Regarding the rationale given by the Applicant regarding their mitigation for the village of Stoney Stanton regarding Traffic and Roads.

The Applicant said in the hearing on 31st October 2023, that the proposed traffic lights with signals at the Hinckley Road / Station

Road / New road junction in Stoney Stanton (listed as B1 in Table 8.28 were to create a delay for traffic, and this was to be the deterrent for construction lorries.

Drawing Title
**JUNCTION 17 - B581 /
HINCKLEY ROAD / NEW
ROAD
PROPOSED SIGNALS**

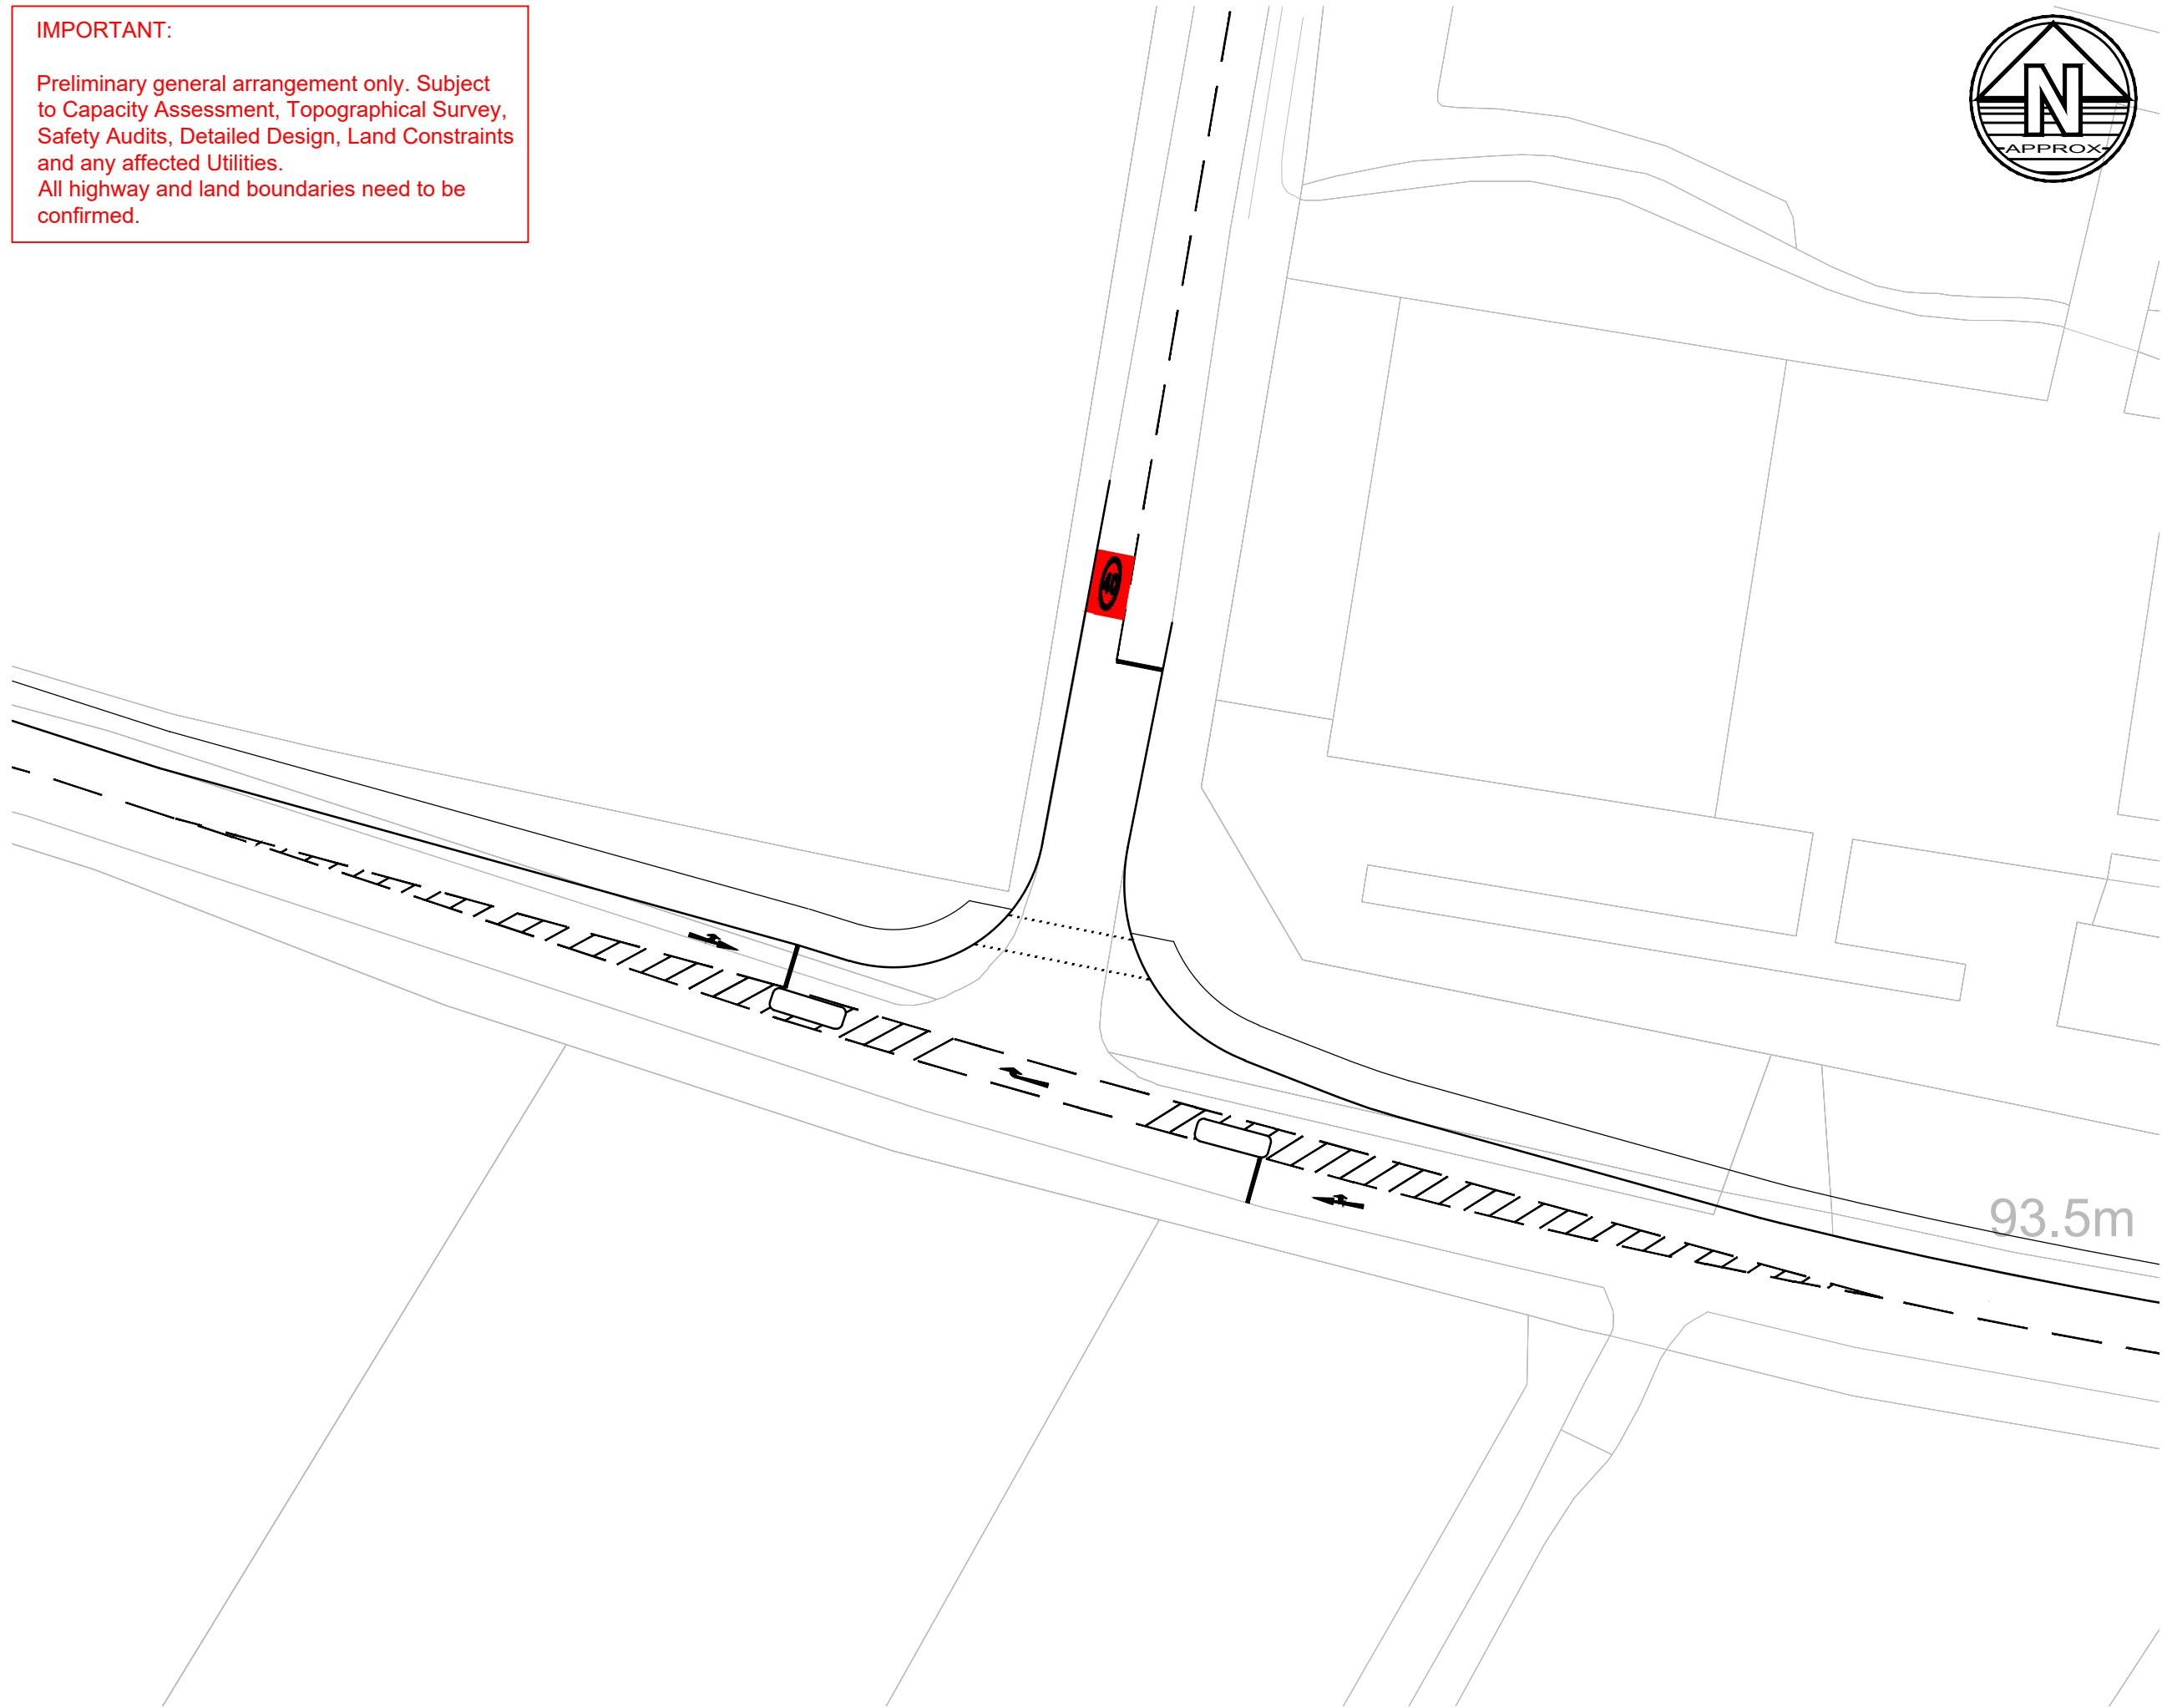
I would like to know what how much time the delay is calculated to be?

and how this was calculated?

How will this be monitored and ensure it is successful as a deterrent?

I would request further visits to this site, to see how this will work as resident car parking on both sides of Hinckley Road will mean that queueing traffic for the lights at the roundabout will block traffic trying to exit Stoney Stanton via Hinckley Road and most likely cause a traffic jam.

Current heavy traffic that we see in Stoney Stanton just about manages the current road lay-out, and the roundabout suggested to have the traffic lights actually 'works' for the most part, even though it can be busy.

I don't feel that all Stoney Stanton residents, in addition to all those car users coming to Stoney Stanton as daily incidental traffic should suffer delays and congestion, just as a deterrent which isn't guaranteed to work.

Drawing Title
**JUNCTION 19 - B4669 /
STANTON LANE
PROPOSED MITIGATION**

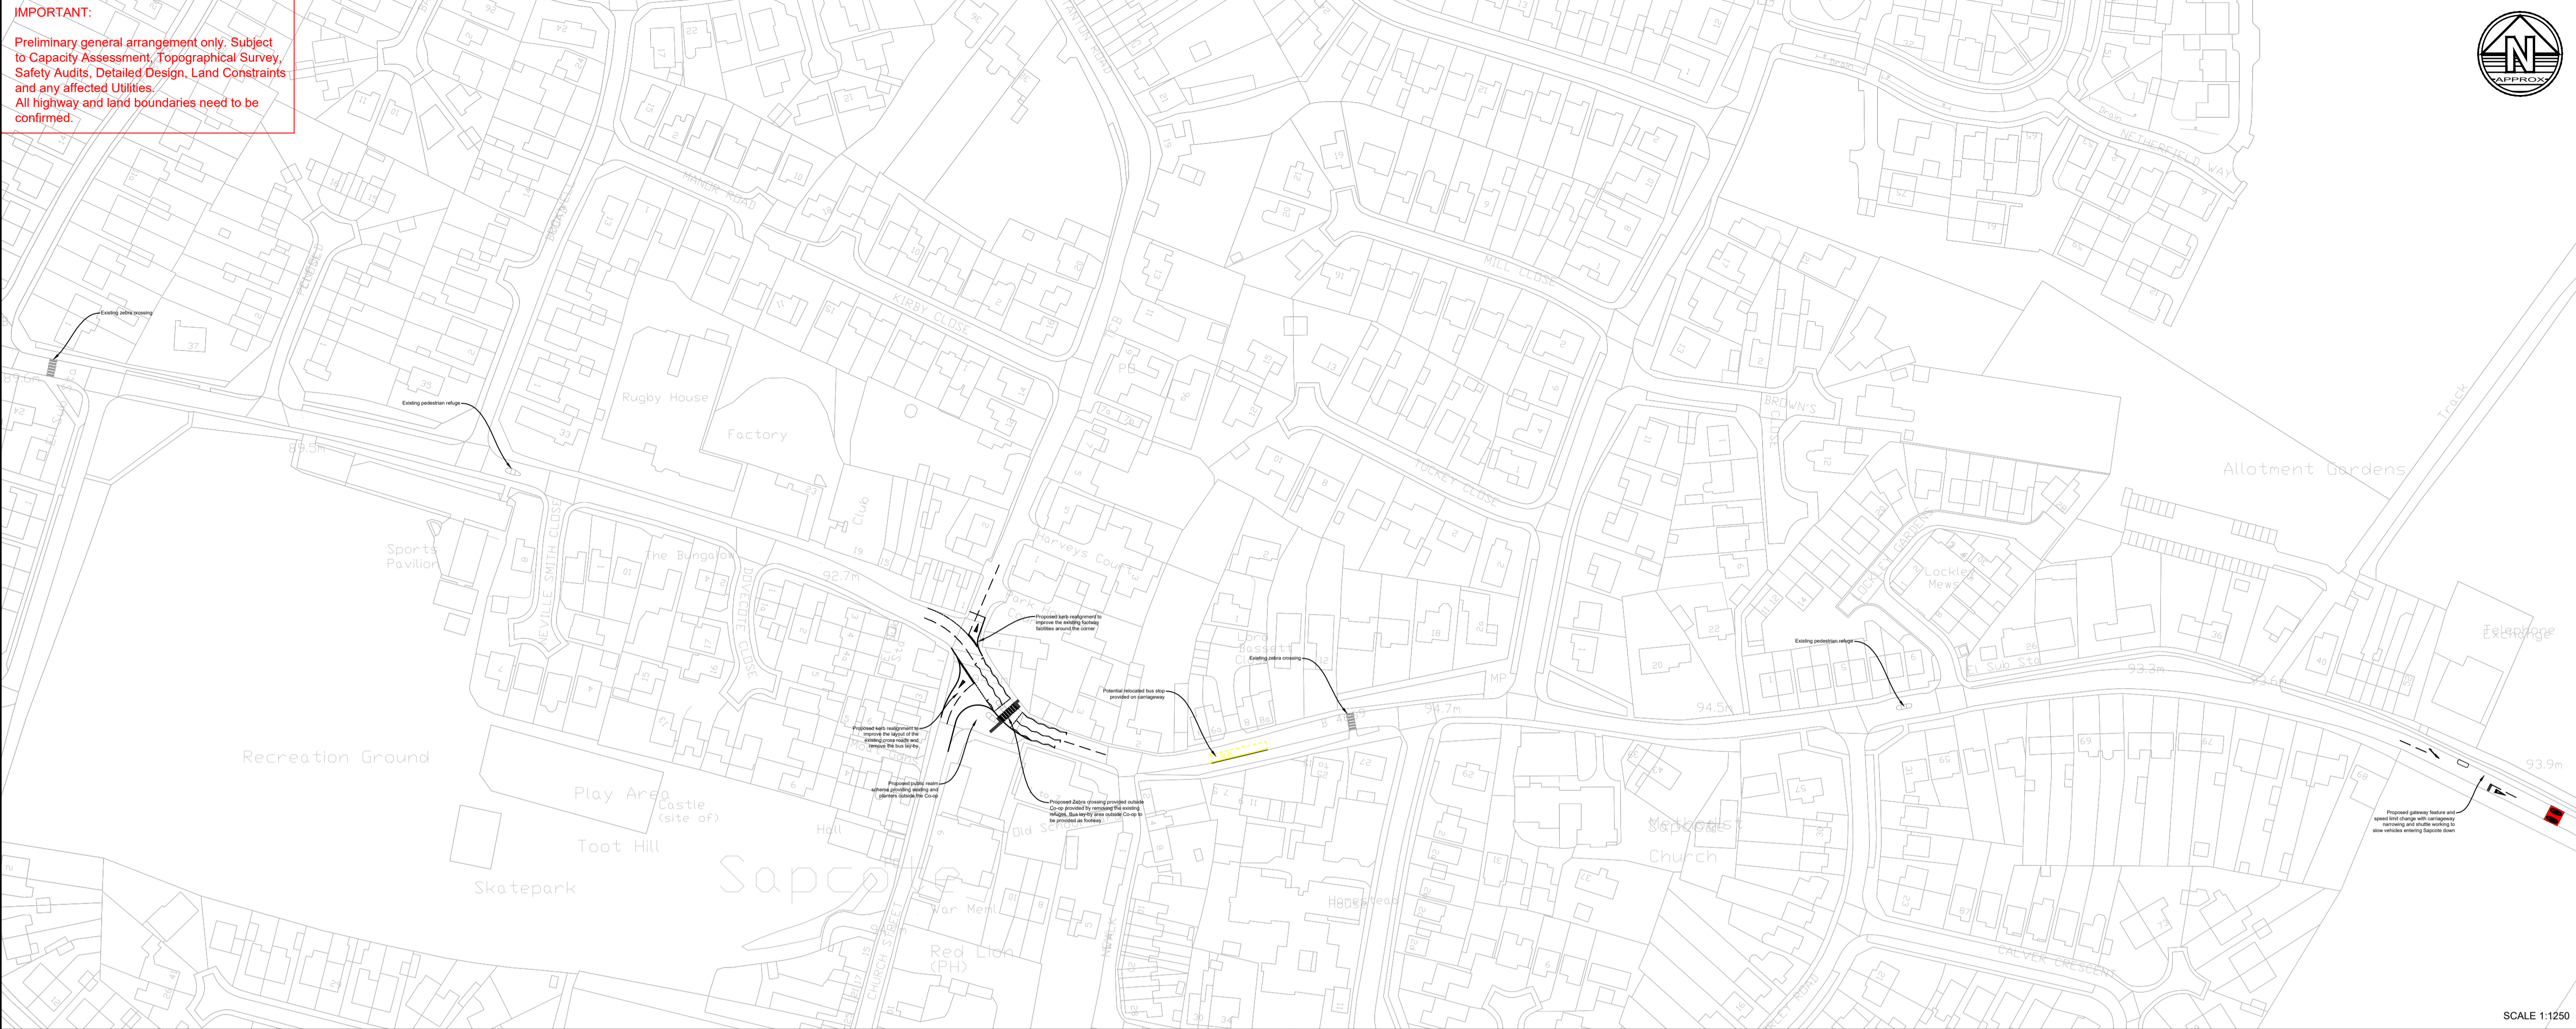
The traffic on Hinckley Road will be further exacerbated by the addition of more traffic lights at the B4669 / Stanton Lane junction (listed as B2 in Table 8.28 of APP-117 ES Chapter 8); This will cause continuous lines of vehicles coming into Stoney Stanton on Hinckley Road with no breaks in the traffic flow.
